**From:** [REDACTED]  
**To:** [A585 Windy Harbour to Skippool](#)  
**Subject:** Deadline 3 submission from J Bailie  
**Date:** 31 May 2019 13:12:55

4. As it is impossible to examine all those submissions in detail within that limited time scale, I refer to my Deadline 2 submission and would emphasise my particular concern regarding the ability / necessity for traffic to carry out U-turns (which involve negotiating around traffic islands) at the Skippool and Skippool Bridge Junctions.

Insert 2-2: Description of the Scheme - The Scheme

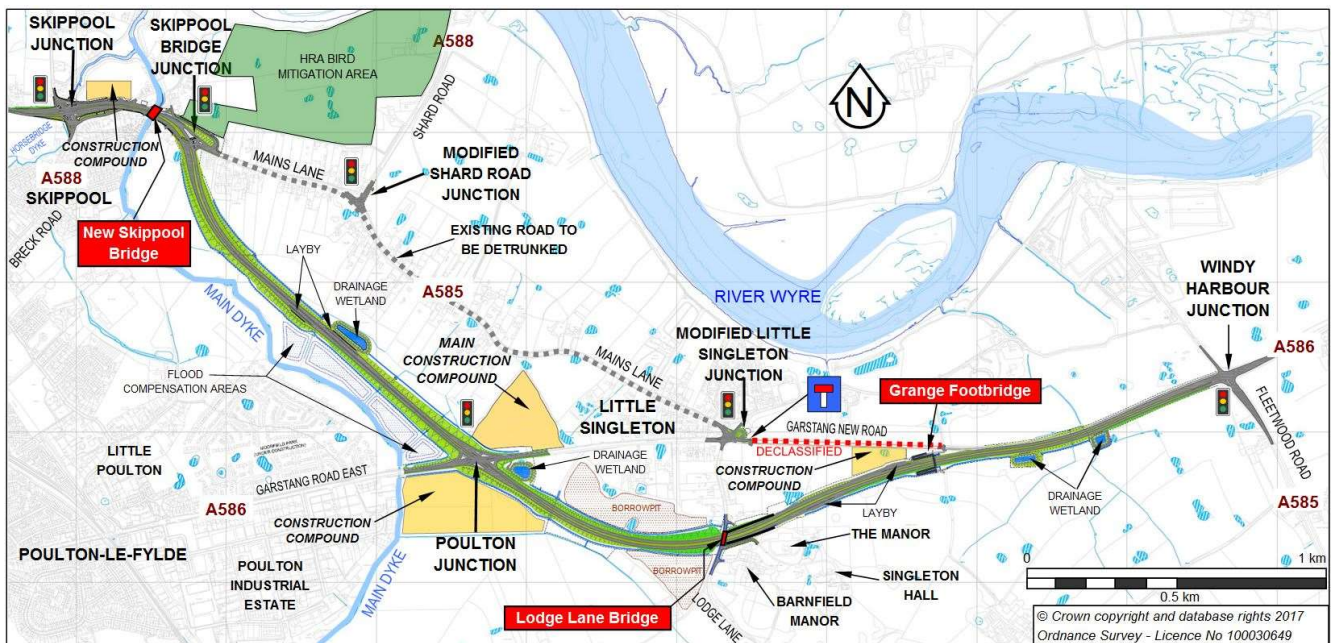
These particularly complex junctions, necessitating the demolition of several properties and the destruction of trees and hedgerows, to be replaced by oceans of tarmac and forests of traffic signals combined with the ability to execute these convoluted U-turns, will not only interrupt traffic flows and create more congestion and pollution but will visually create an eyesore at what is a landmark approach to the town of Poulton-le-Fylde and the approaches to Thornton.
